**Re: Minor Modification to First Floor window to
Bedroom 3 on Plot 3 only.**

At: "The Old Smithy", 64 Hoyland Road, Hoyland Common, Barnsley. S74 0PB.

Approval No: 2008 / 0653. Approval Date: 12th. June 2008.

PROJECT	Type A Dwelling	
CLIENT	Mr. & Mrs. A. Turner	
TITLE	Elevations & Layouts	
ADDRESS	land adj. "The Old Smithy", Hoyland Rd, Hoyland Common	
DRAWN BY	ggg	
SCALE	1:100; 1:50	DATE Apr. 08
DRAWING No	670-03	REV. 0

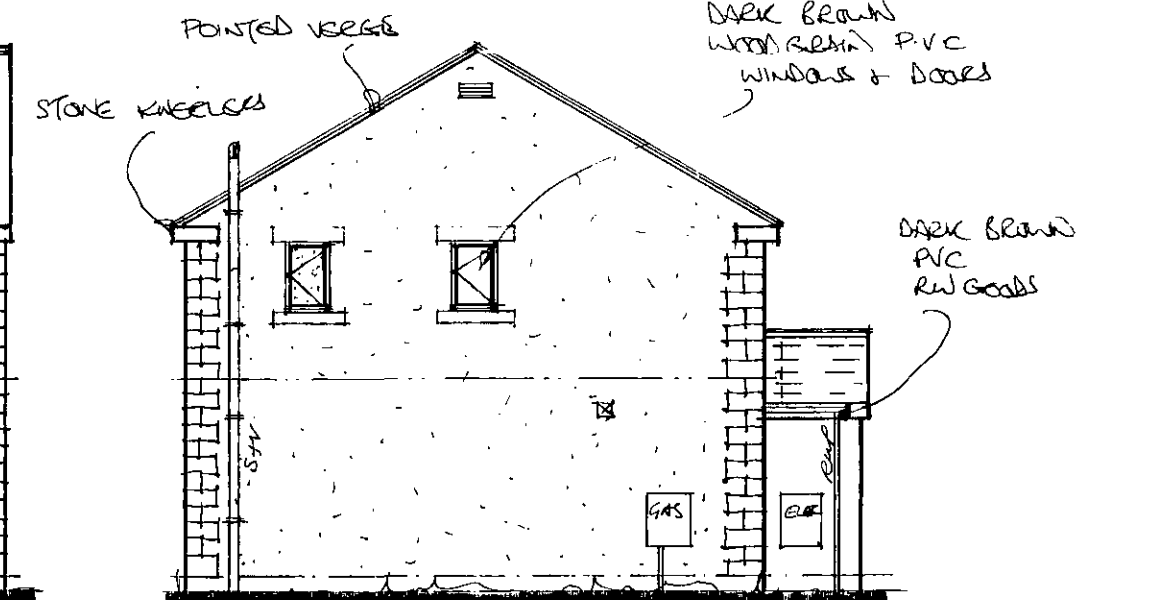
The alterations simply relate to the re-location of the first floor Bedroom 3 window from the side elevation to the rear elevation. Take note that the window sizes do not alter.
